From: Sue Howell
Sent: 10 October 2016 17:32
To: Planning.Responses
Cc: Simon Davis
Subject: RE: Planning Consultation on: AL/83/16/OUT

Comment from Greenspace

APPLICATION **AL/83/16/OUT**

Site Address: Land south & west of Barnside & east of pond
Hook Lane Aldingbourne

ILLUSTRATIVE SITE LAYOUT
AS PROPOSED
1265-P11-E

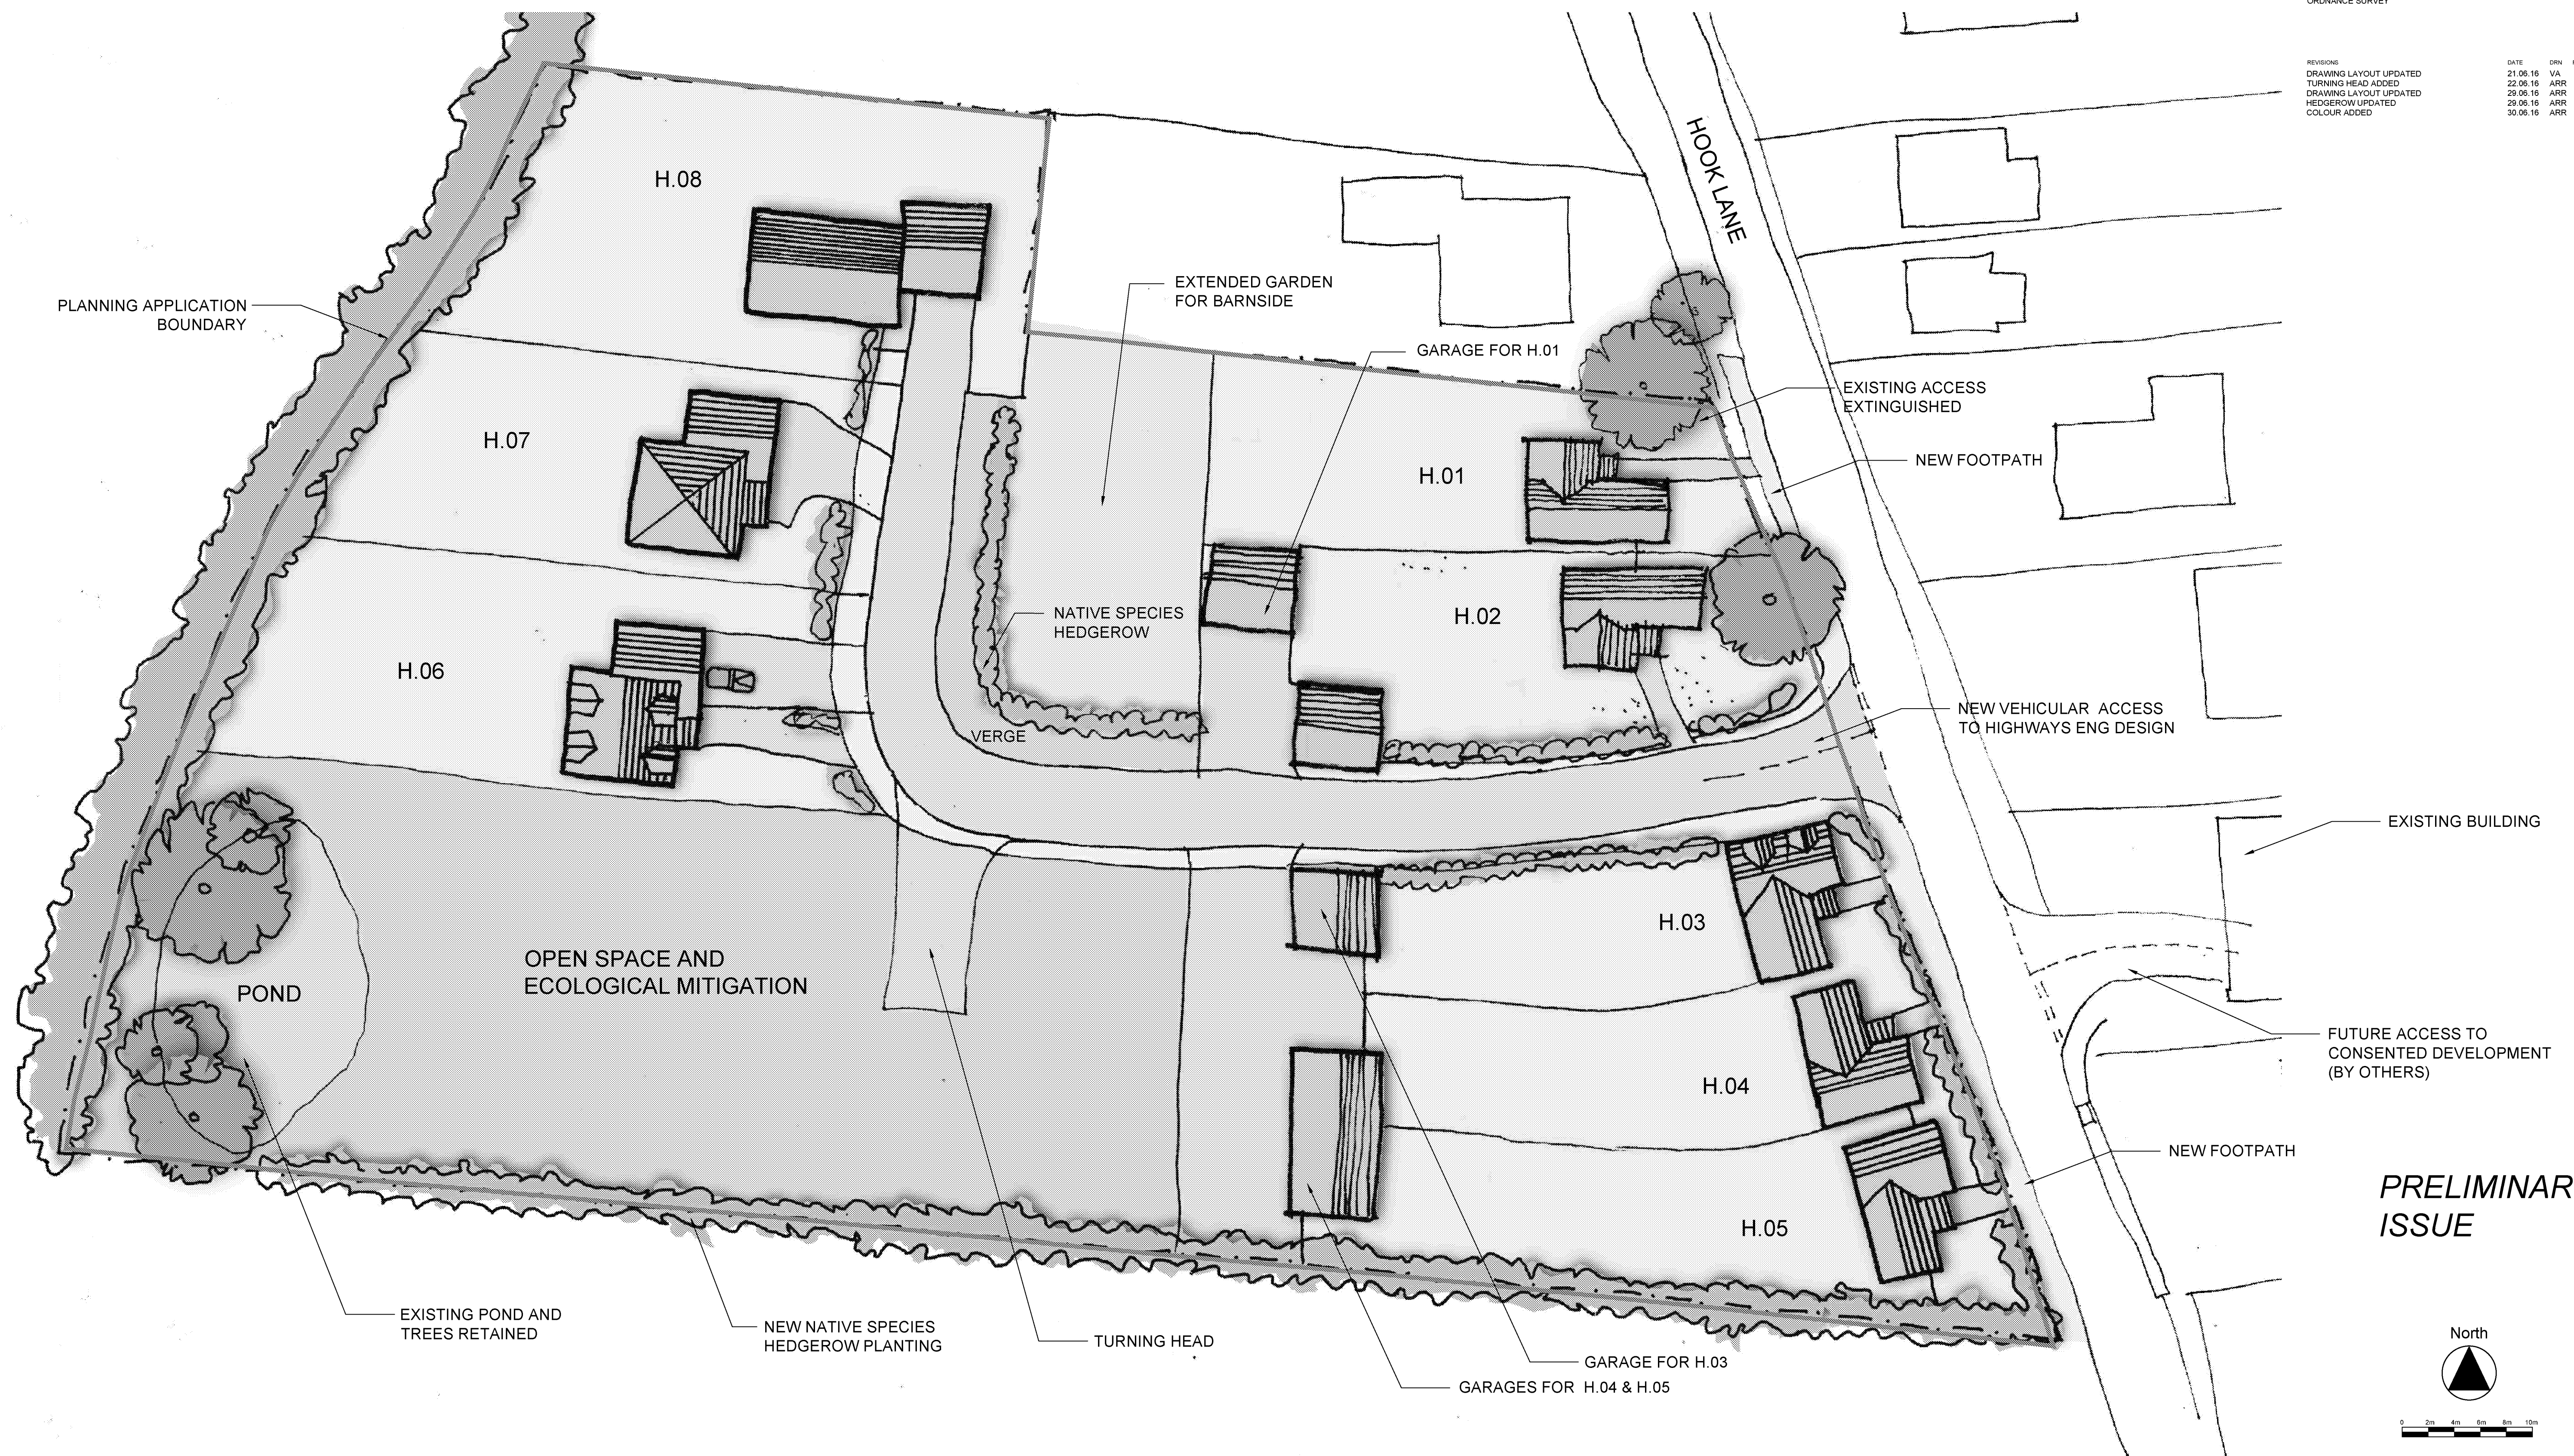
A development of any size would benefit from the inclusion of landscaping to soften the development and allow it to fit within the environment. Prior to any consent being given a full landscape scheme should be submitted for approval, detailing species choice, position, densities and size at time of planting. Landscape plan 1265-P11-F does not adequately show this information. This should be plotted in plan and list form and in relation to the trees and vegetation to be retained so that a clear picture of the proposals can be seen. These details are required to assure the adjacent properties privacy is maintained, screening is to be provided where required and the setting is uncompromised. The present submitted layout plans do not show any landscape detail at present.

Hook Lane Appendix 1 - tree protection plan - phase 1

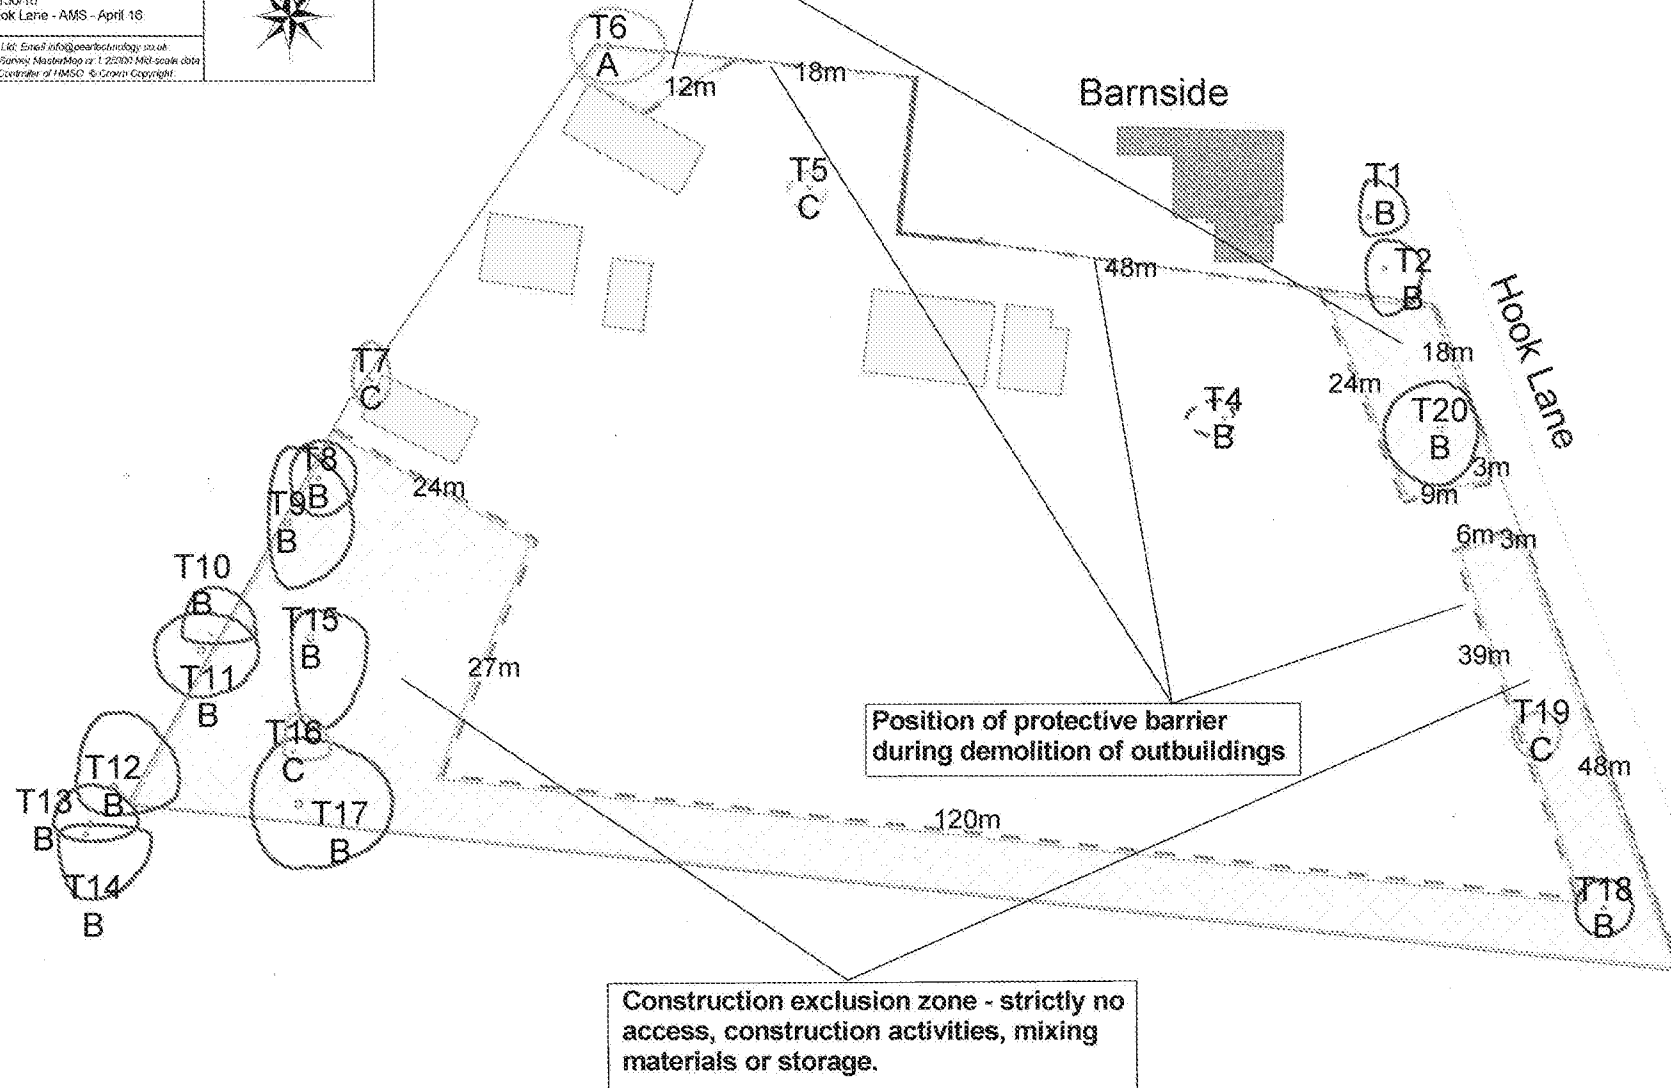
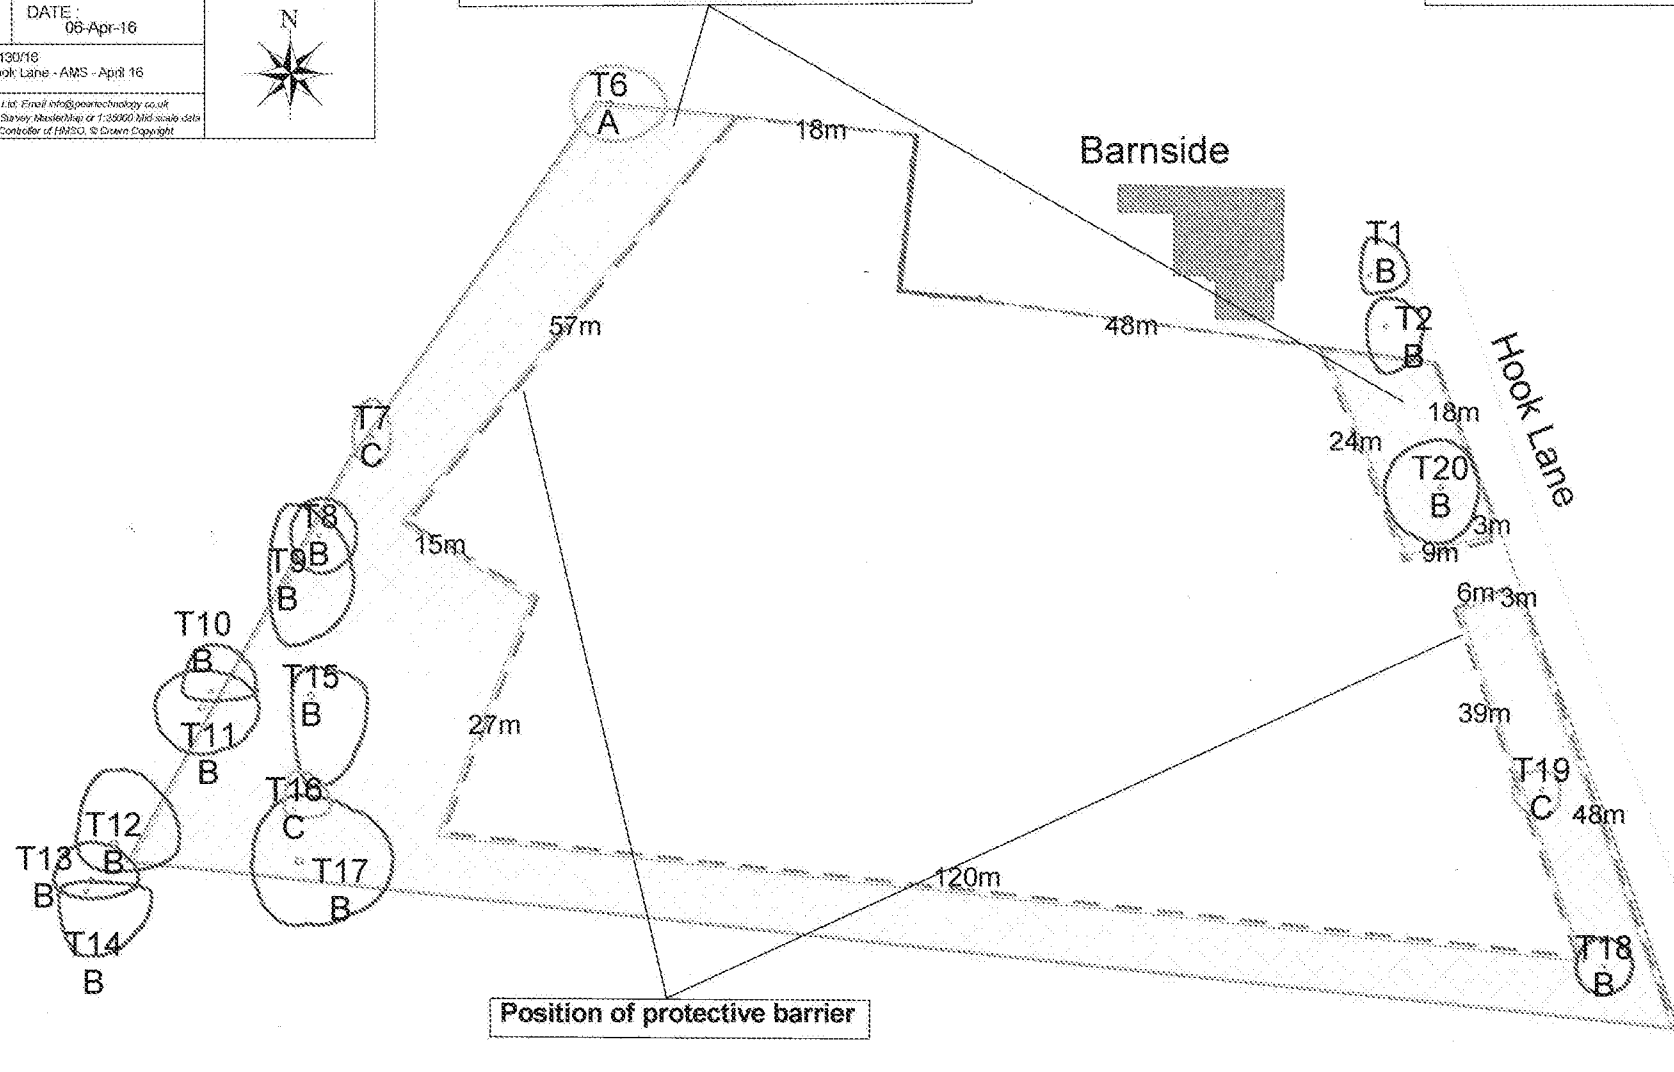
Before construction begins, a tree protection scheme should be submitted for approval detailing the protection measures for any retained trees including trees whose root protection areas fall within the construction zone from neighbouring land. This should be in accordance with BS 5837:2012 'Trees in relation to construction' This will be particularly sought for the area of trees detailed to be retained to the south/west corner pond area of the site.
